Recommendation Report for Planning Permission for Works or Extension to a Dwelling

REF NO: BN/23/19/HH

LOCATION: Cox's Farm
Lake Lane
Barnham
PO22 0AJ

PROPOSAL: Two storey side extension.

DATE	DRAWN	SCALE	NUMBER
APRIL 20189	W	1:100	1828.05

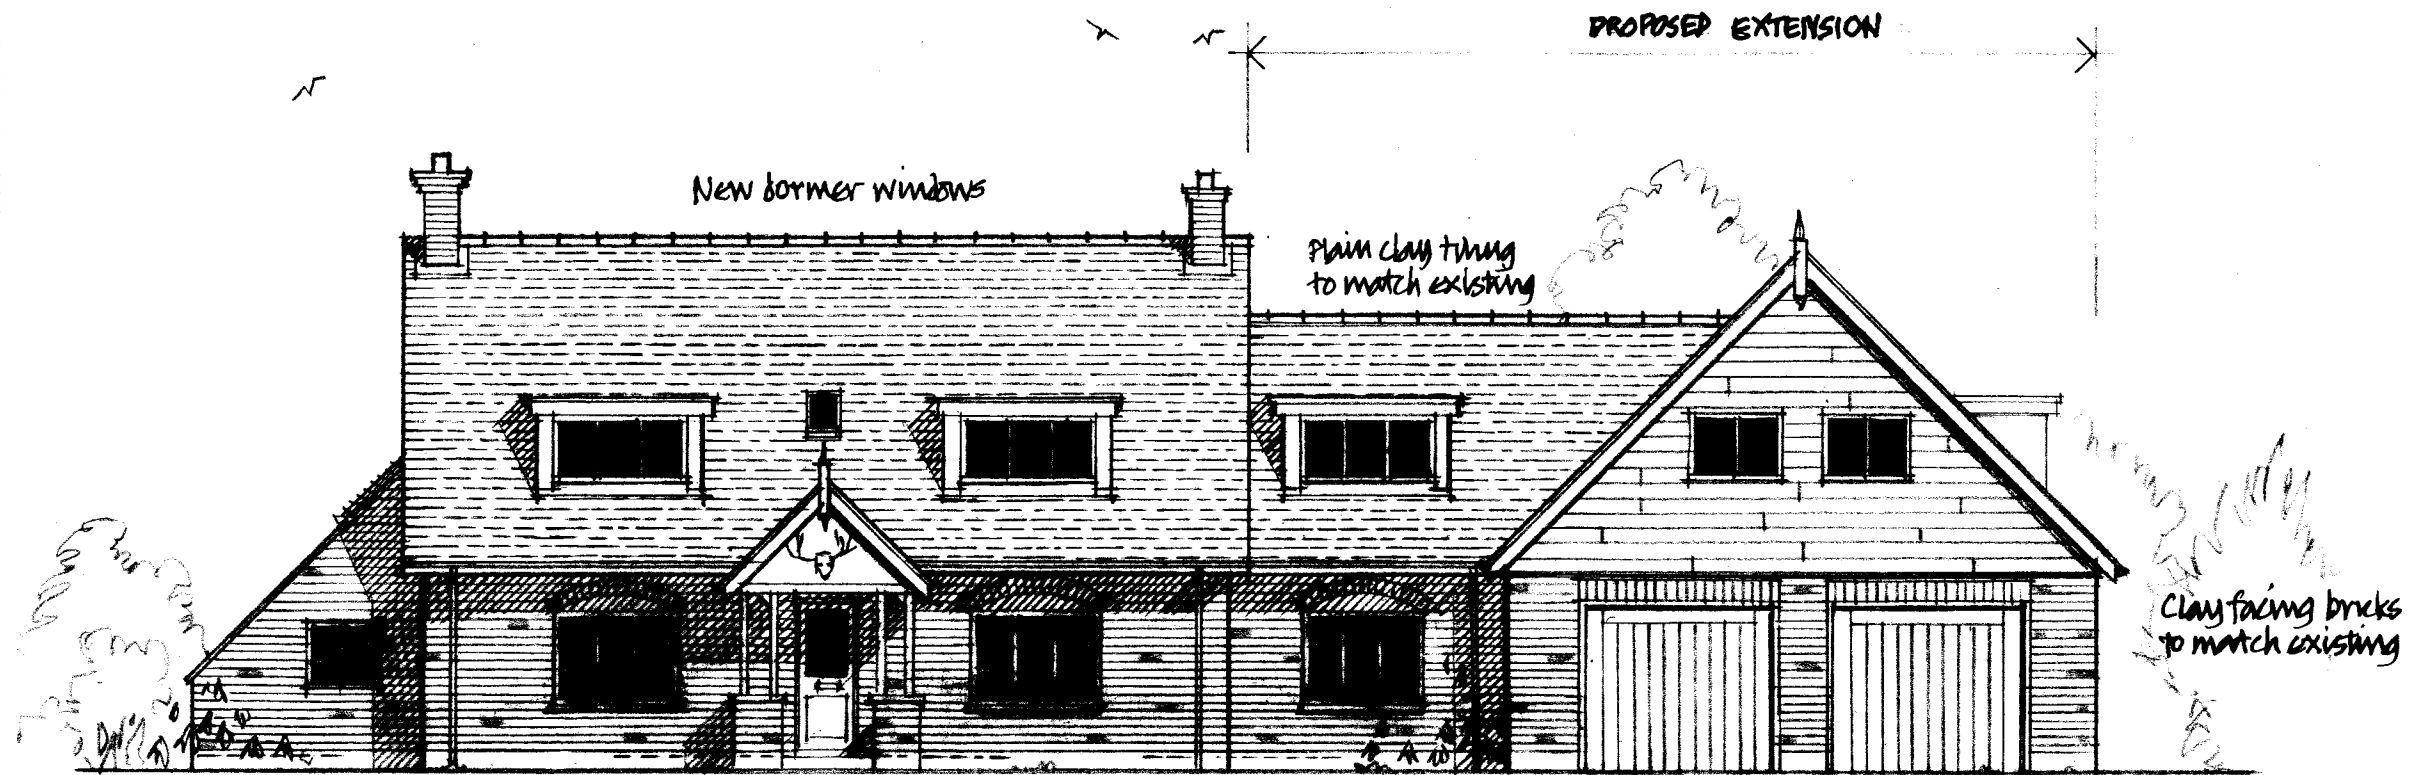
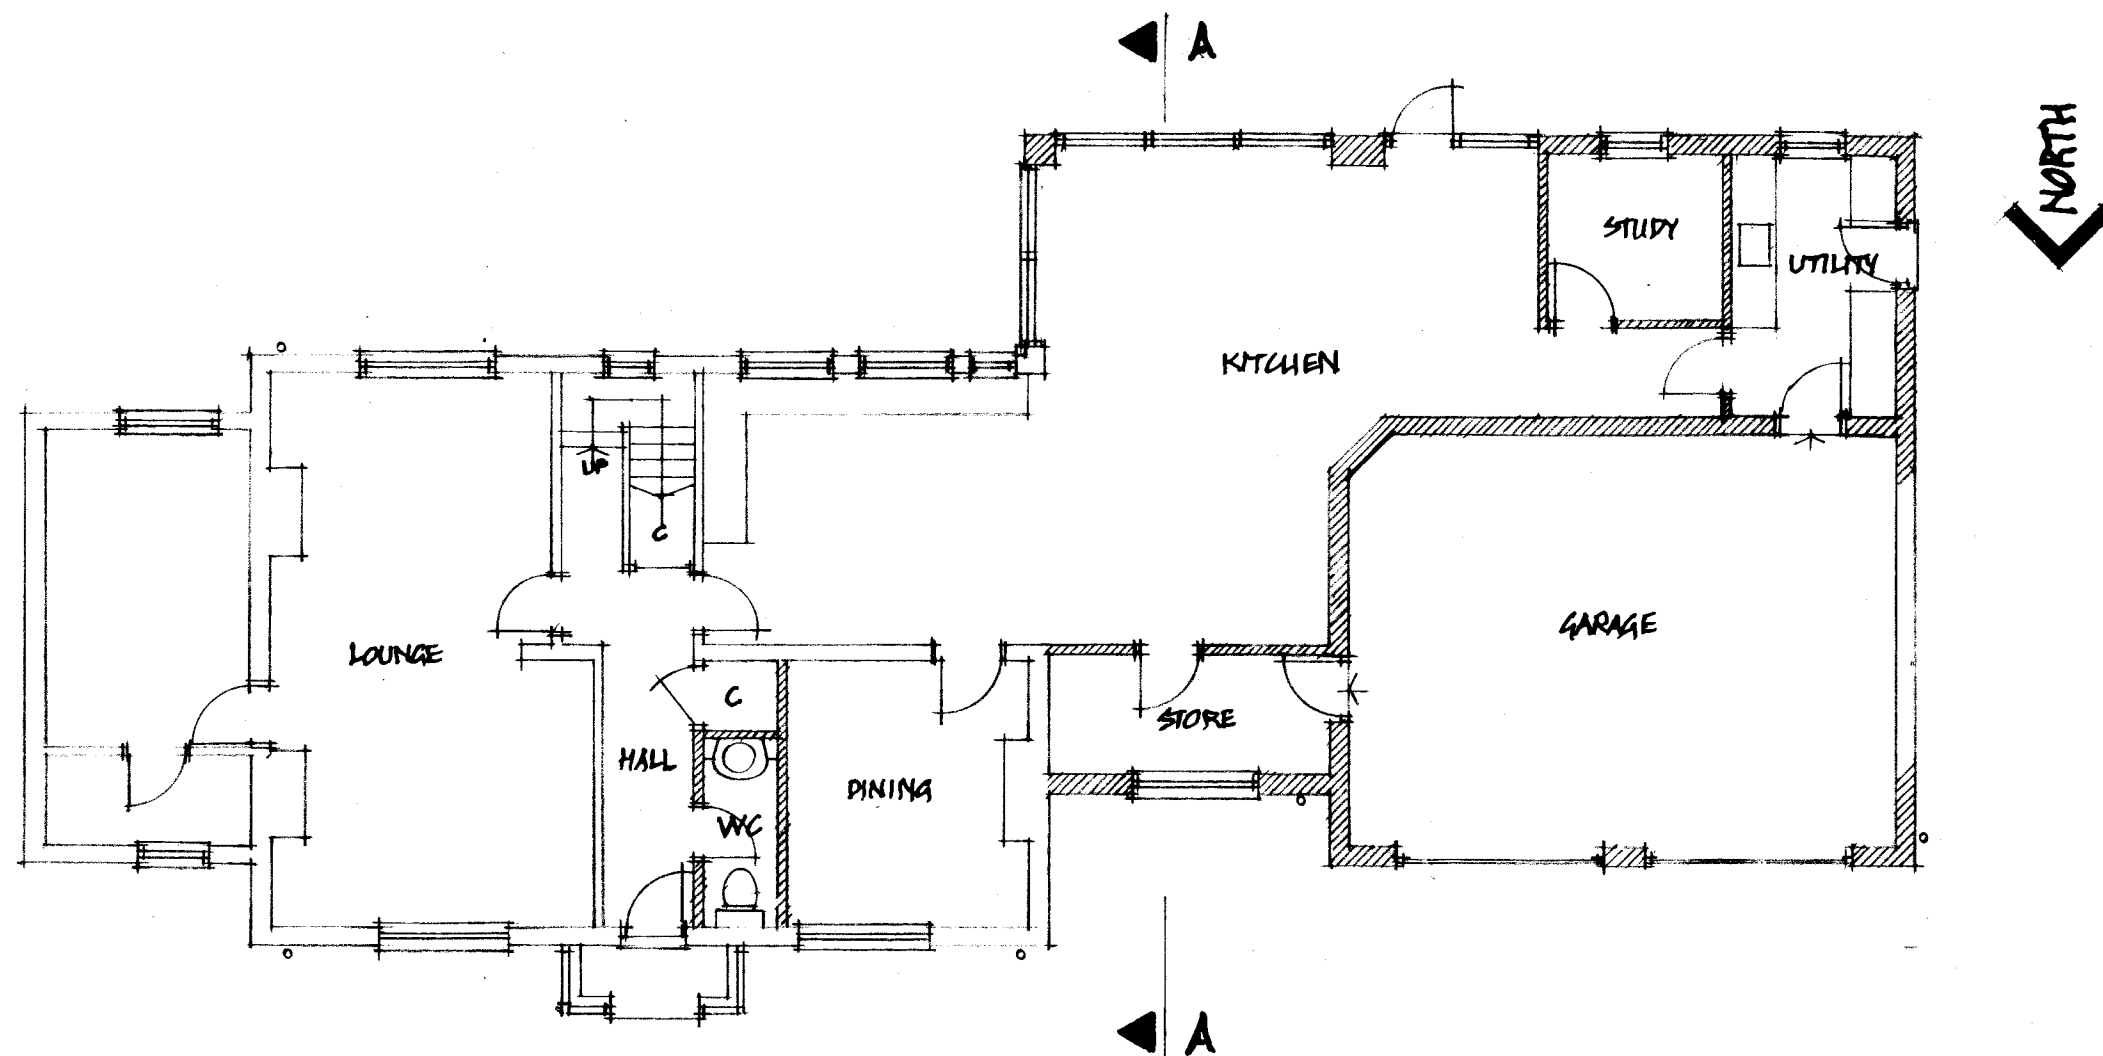
The proposal will construct a two storey extension to the western elevation. This will replace an existing single storey garage. It will have a width of 12.2m and a depth of 10m. It sits behind the principal elevation by approximately 2.2m and extends 3m beyond the rear. It will have ridge height below that of the host dwelling with a gable projection forming a double garage to the front elevation.

APRIL 2019 W 1:100 1828.06

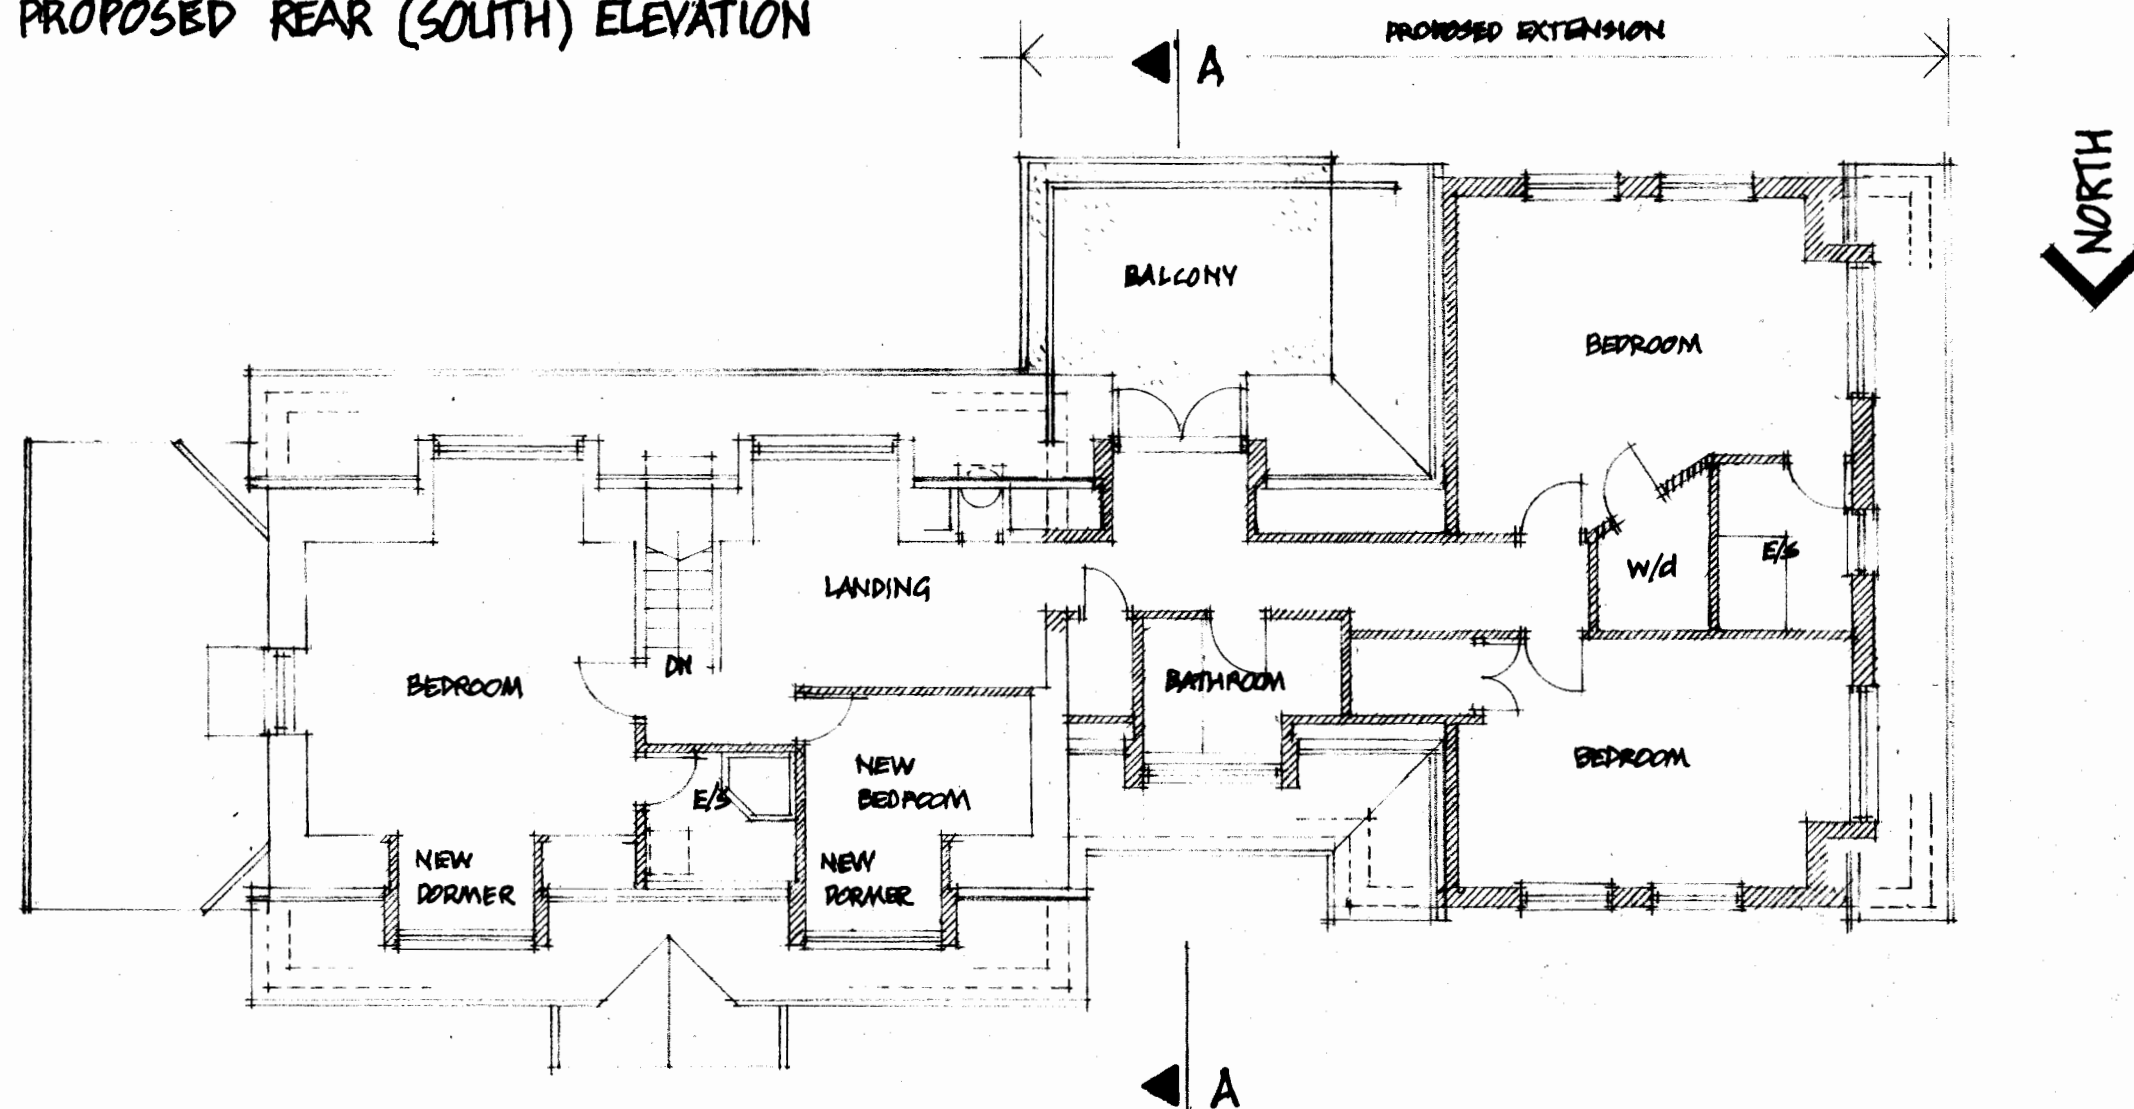
The extension will also create a balcony to the rear elevation with views facing south and east. Due to the siting and with no properties to the rear or side it is not deemed to give rise to any adverse impacts.

Whilst the proposal features new openings at both ground and first floor as a result of the siting, it is not considered that any of these give rise to adverse overlooking with no neighbouring properties to the side or rear elevations with 18m retained to the rear and 3m to west. The additional dormer windows to the existing building will overlook the street scene and again are not considered to give rise to adverse overlooking.

APRIL 20189	W	1:100	1828.07
-------------	---	-------	---------

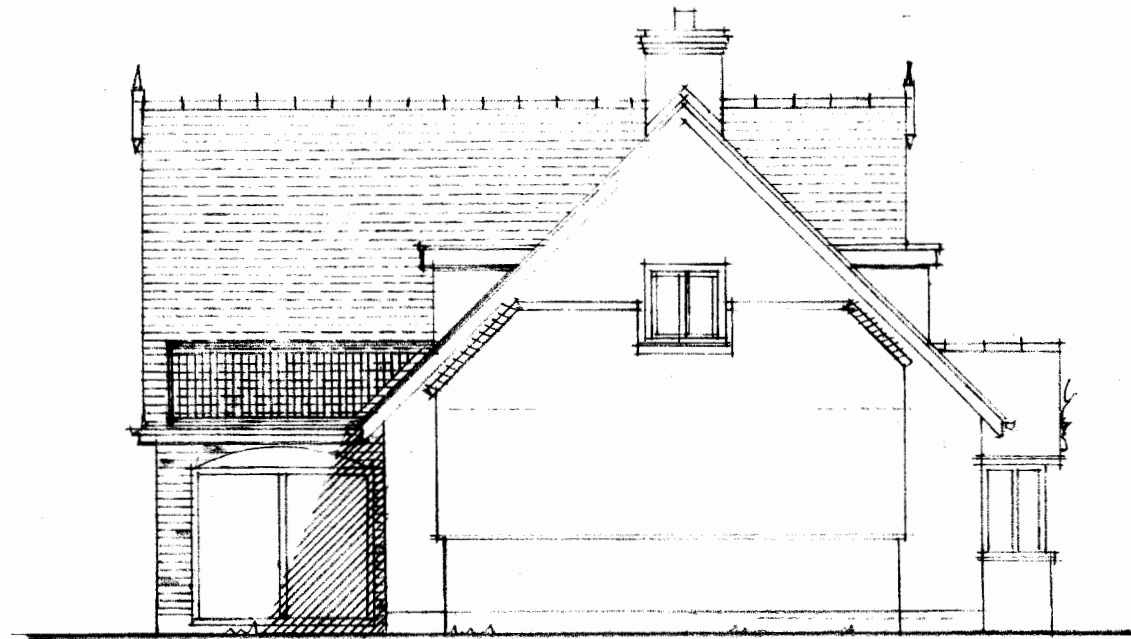
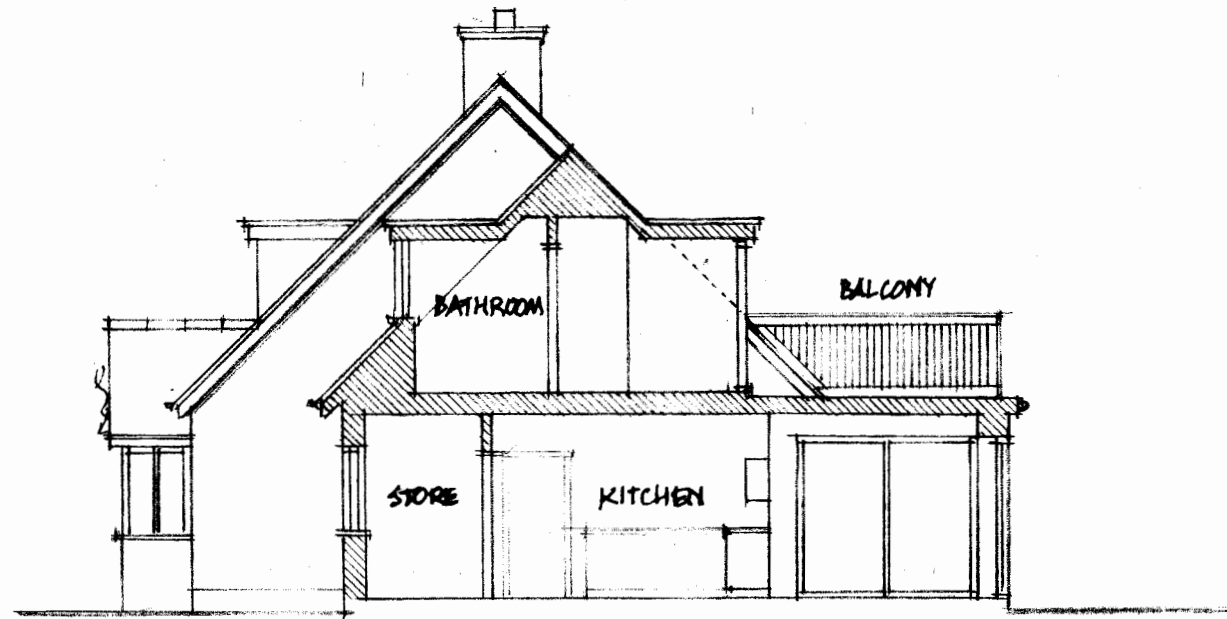
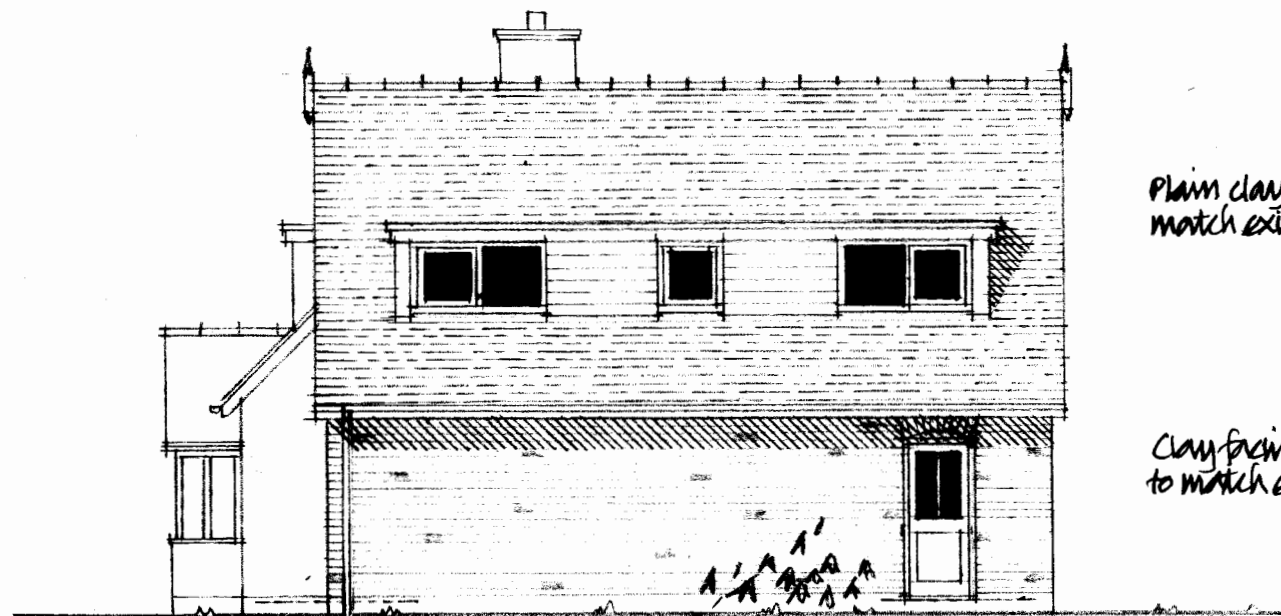
Materials proposed will match that of the existing dwelling and whilst the extension is large the surrounding properties of a varied design and style and it is not considered to result in the dwelling appearing out of character.
